As with the public consultation, Gate Burton Energy Park Ltd has applied the principle of a Rochdale Envelope as an excuse not to provide detailed evidence on their application. Instead of applying a "cautious and worst case approach" they have not provided any detail on major aspects of their scheme in the draft Development Consent Order.

FIGURE NUMBER
 Figure EN010131/APP/3.8

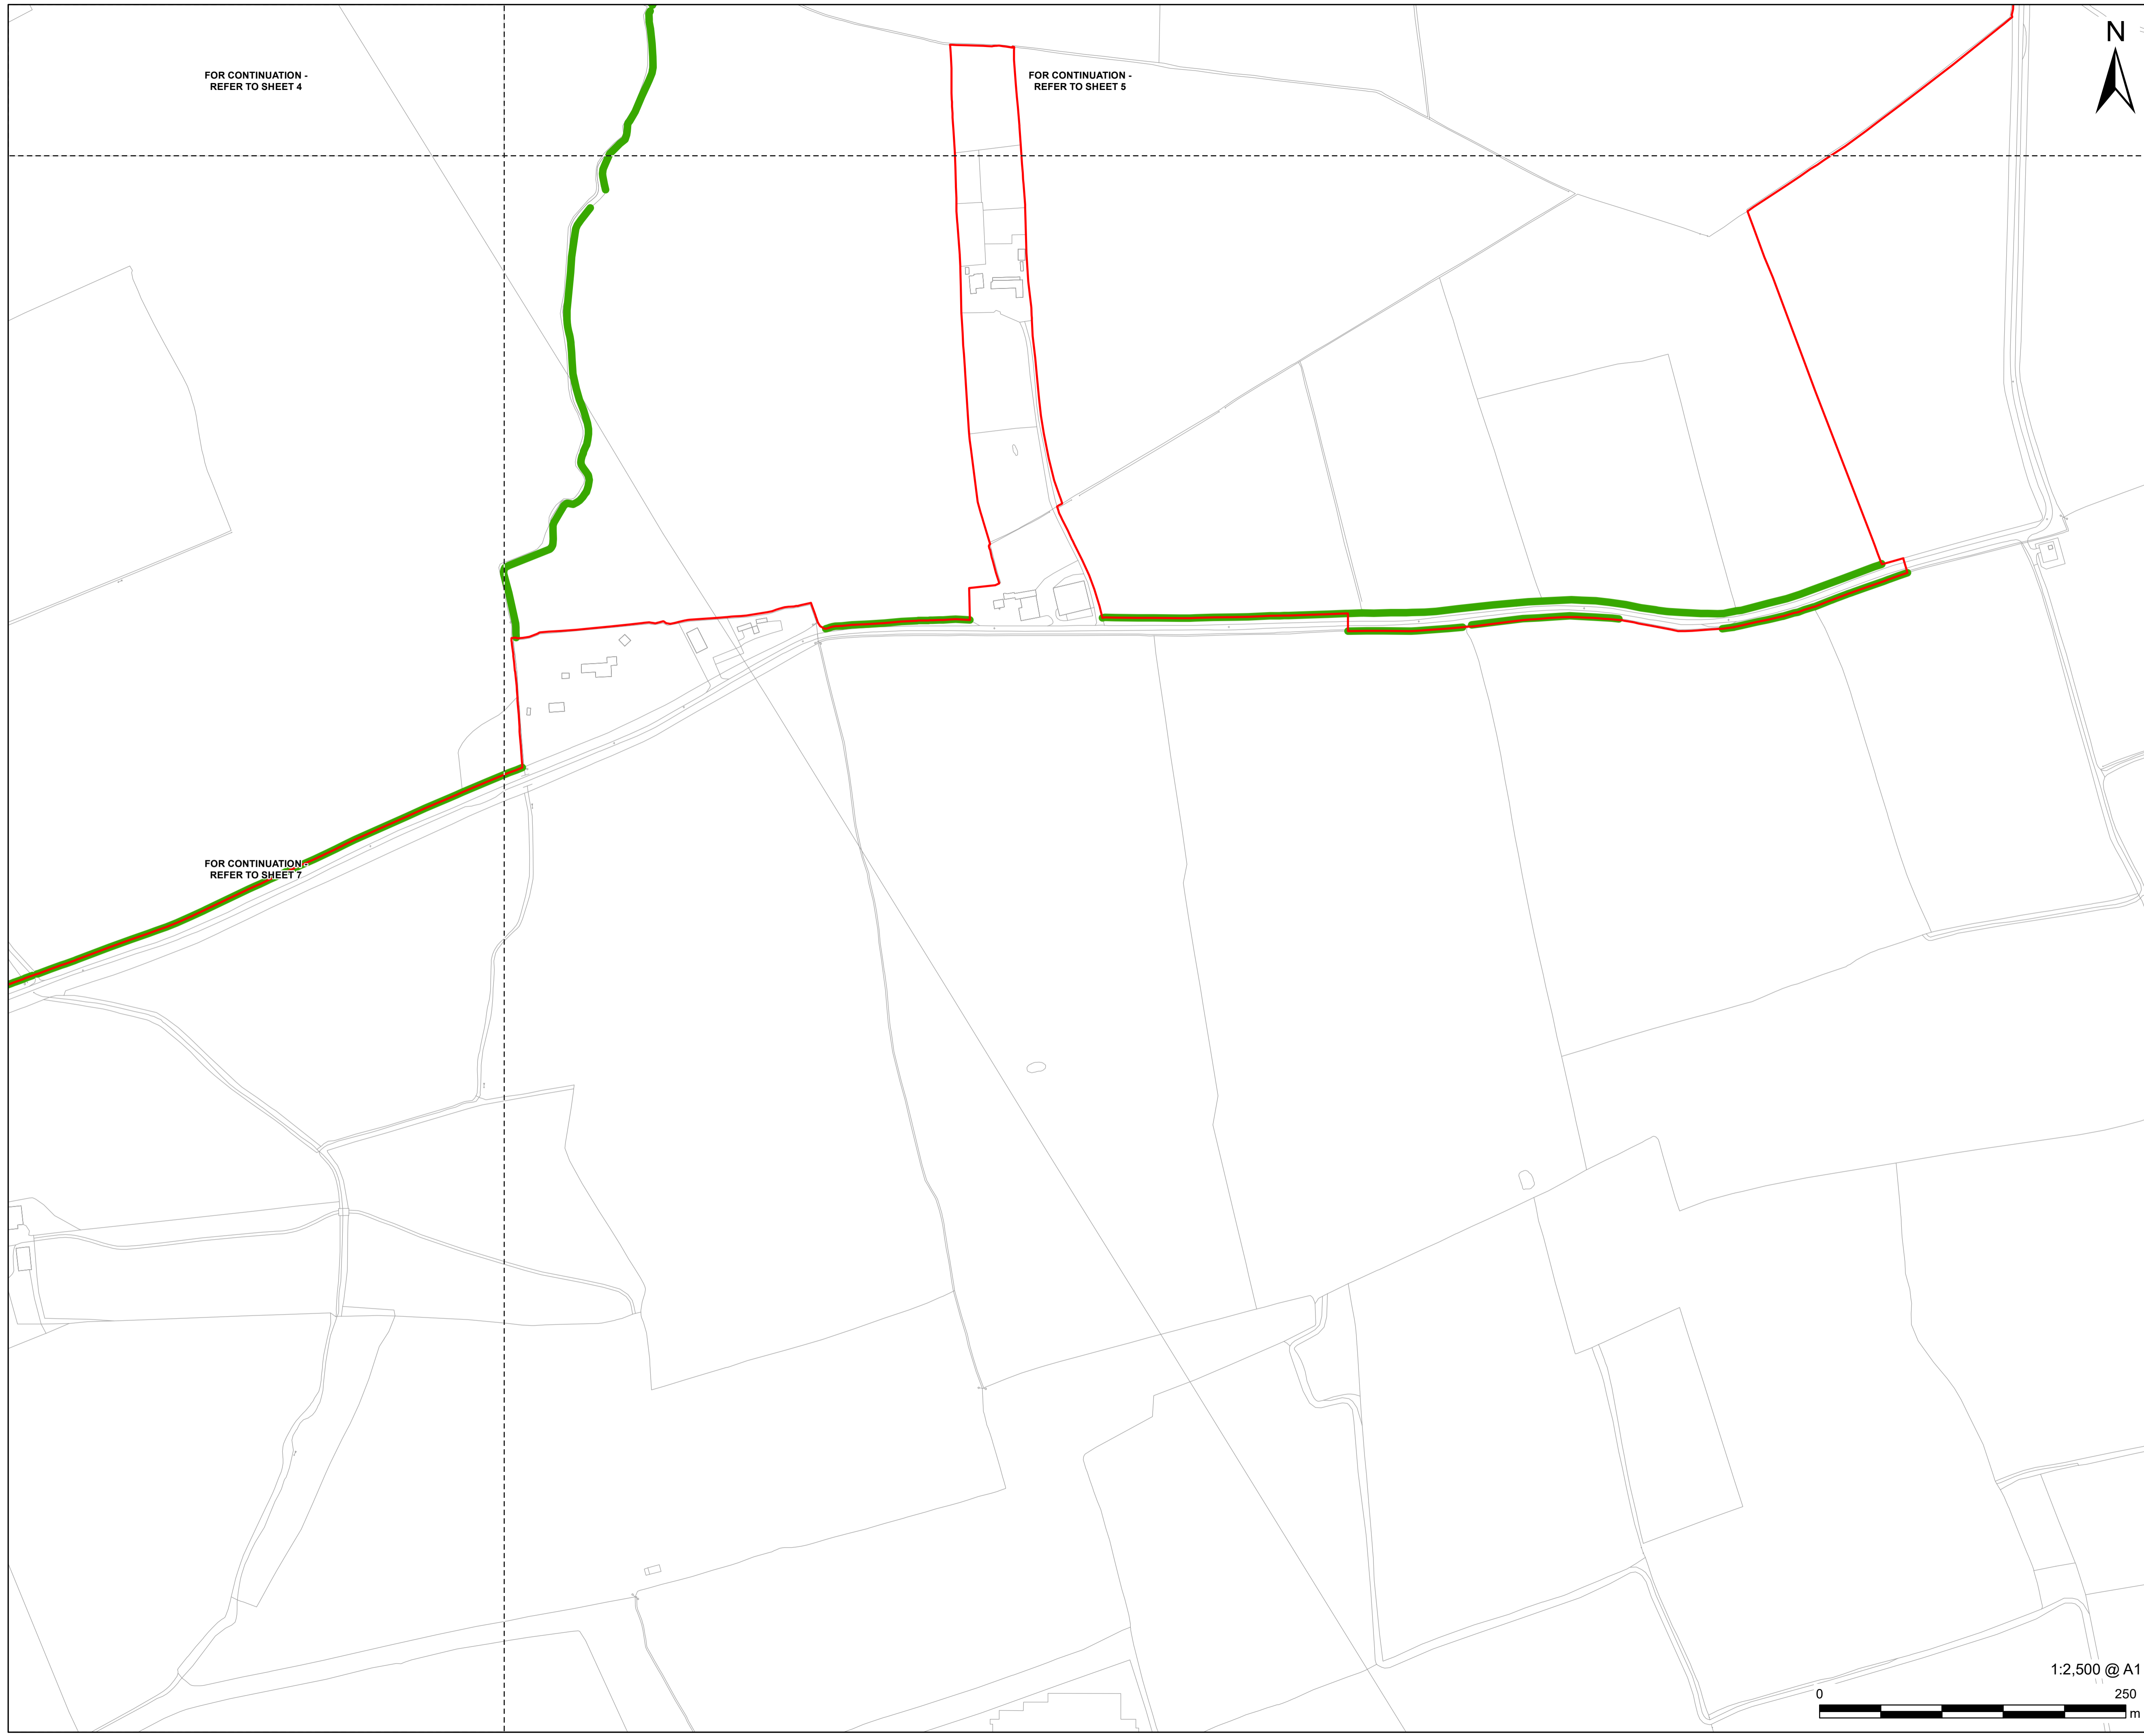
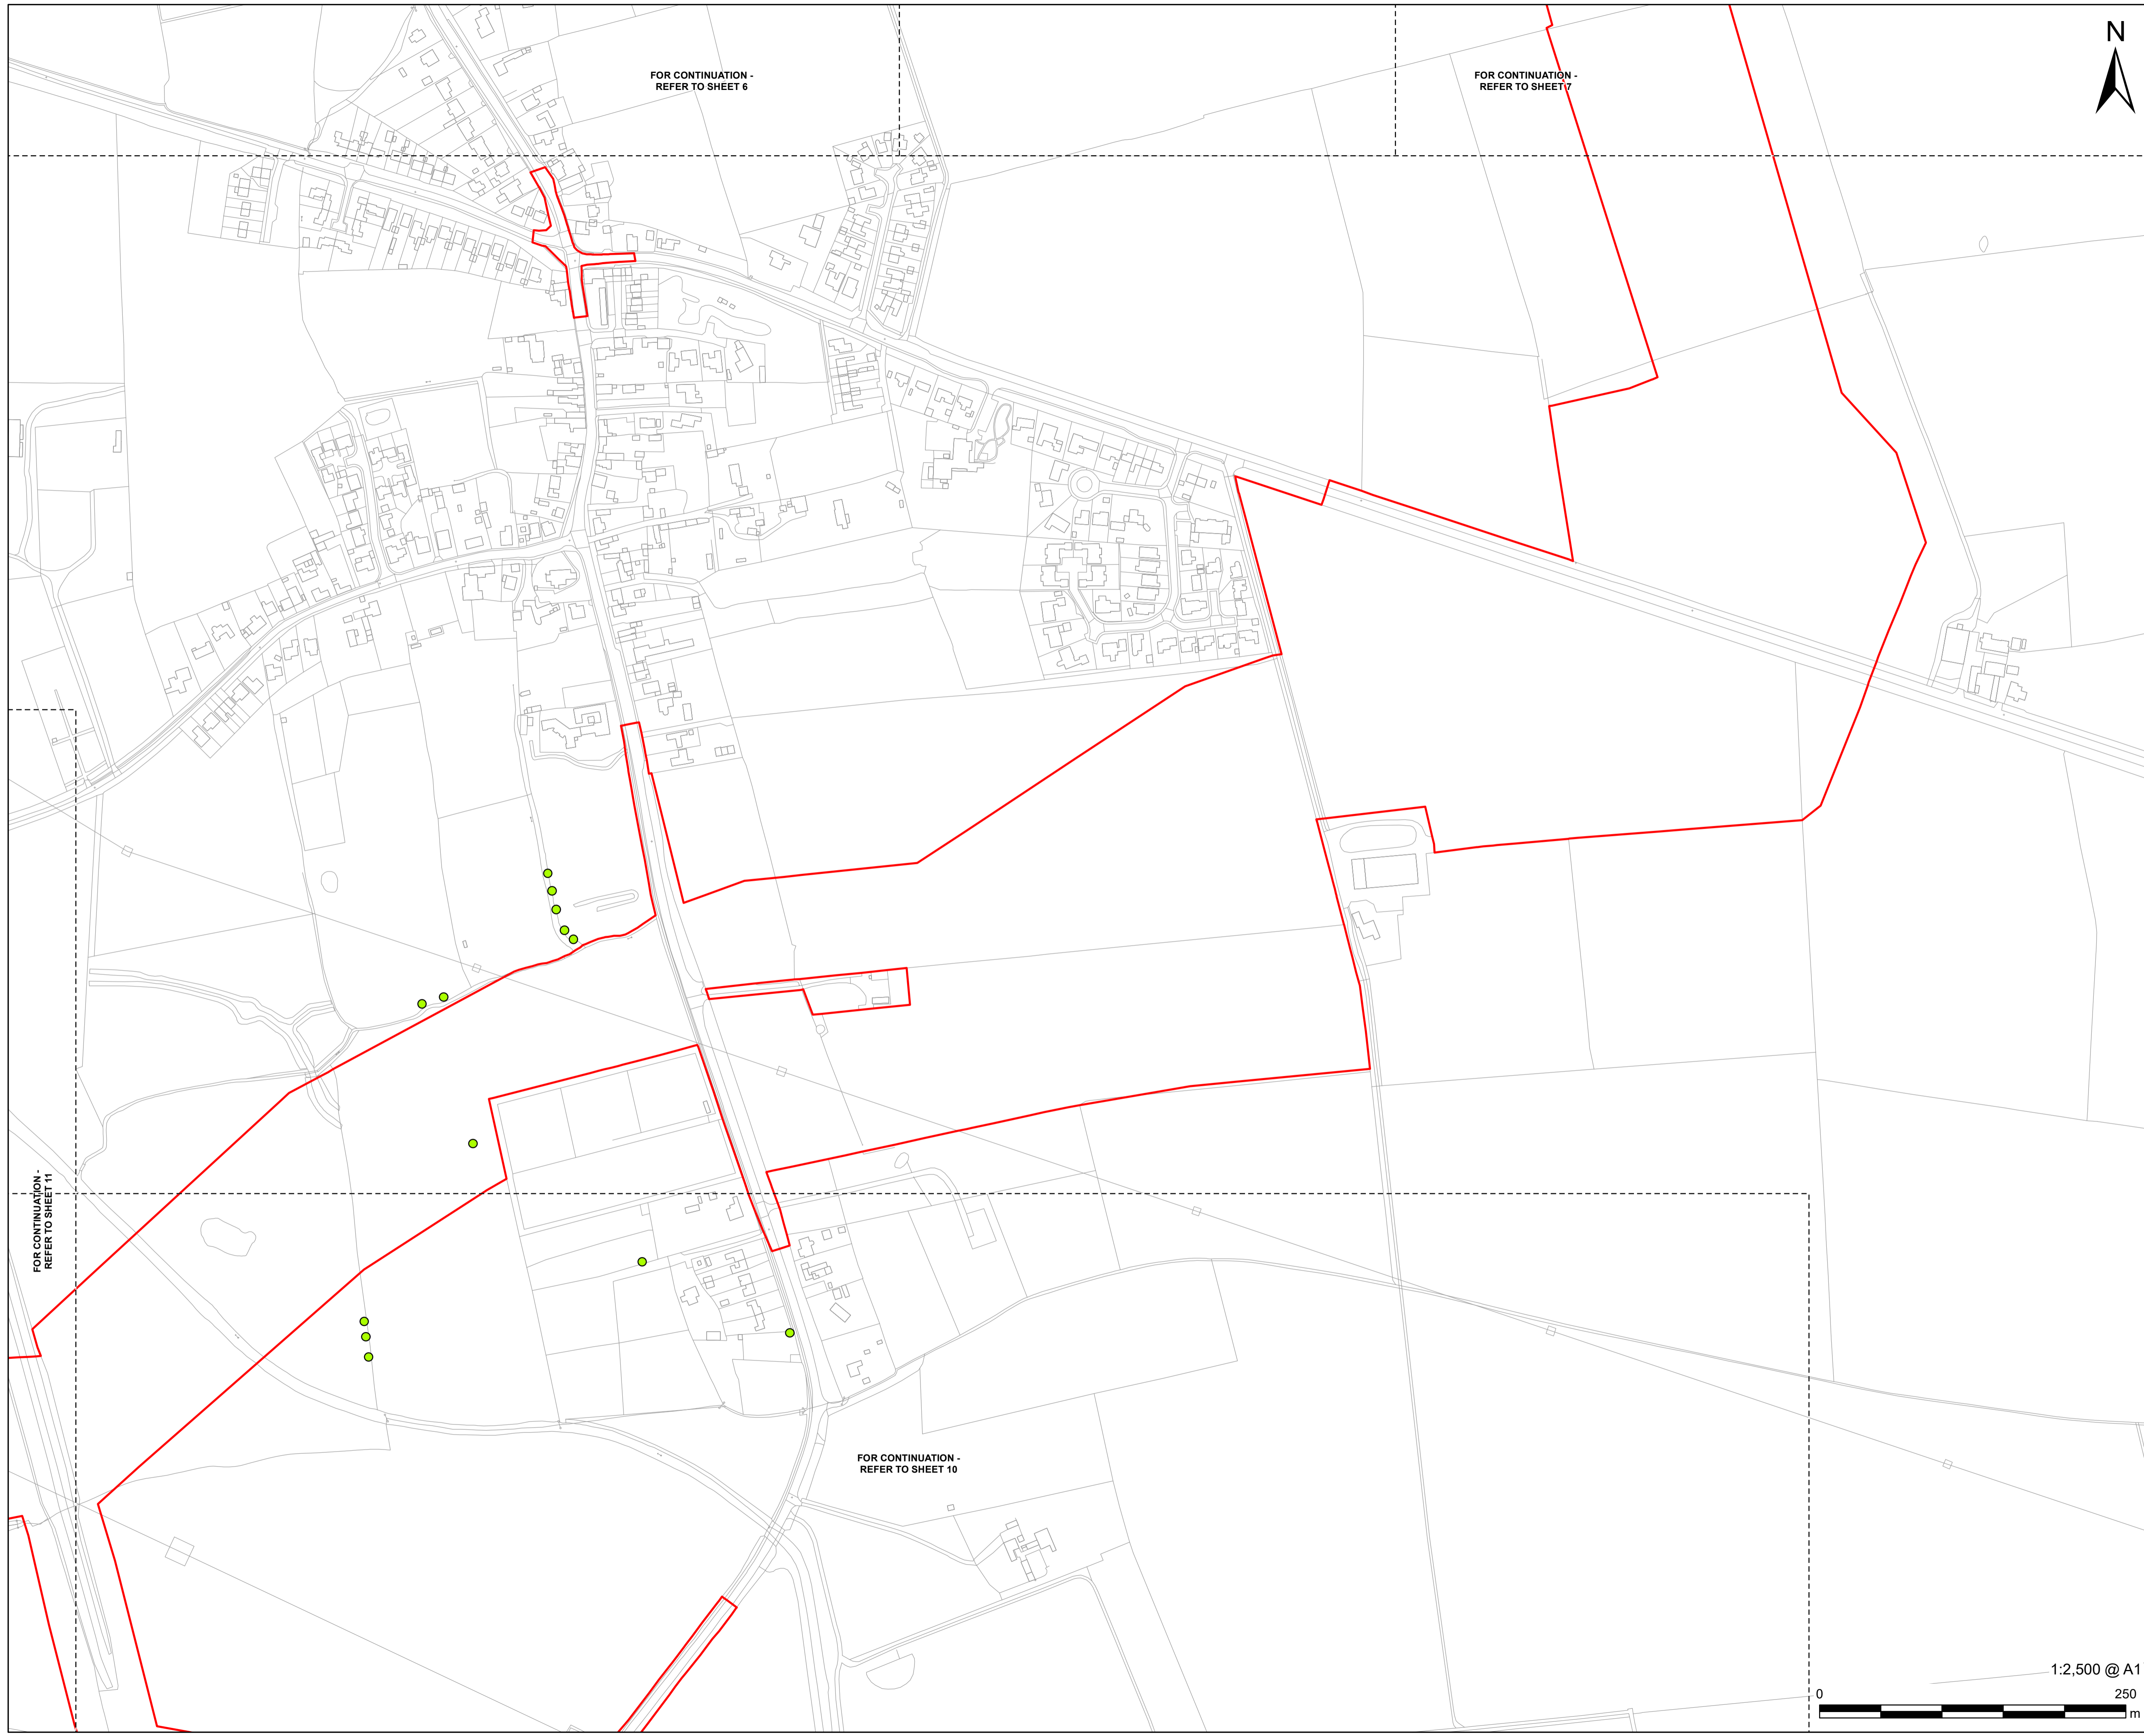
- No information on the scale of hedgerow and tree removal is provided. The adjacent Cottam dDCO provides full disclosure of the circa 55km of hedgerows to be destroyed.
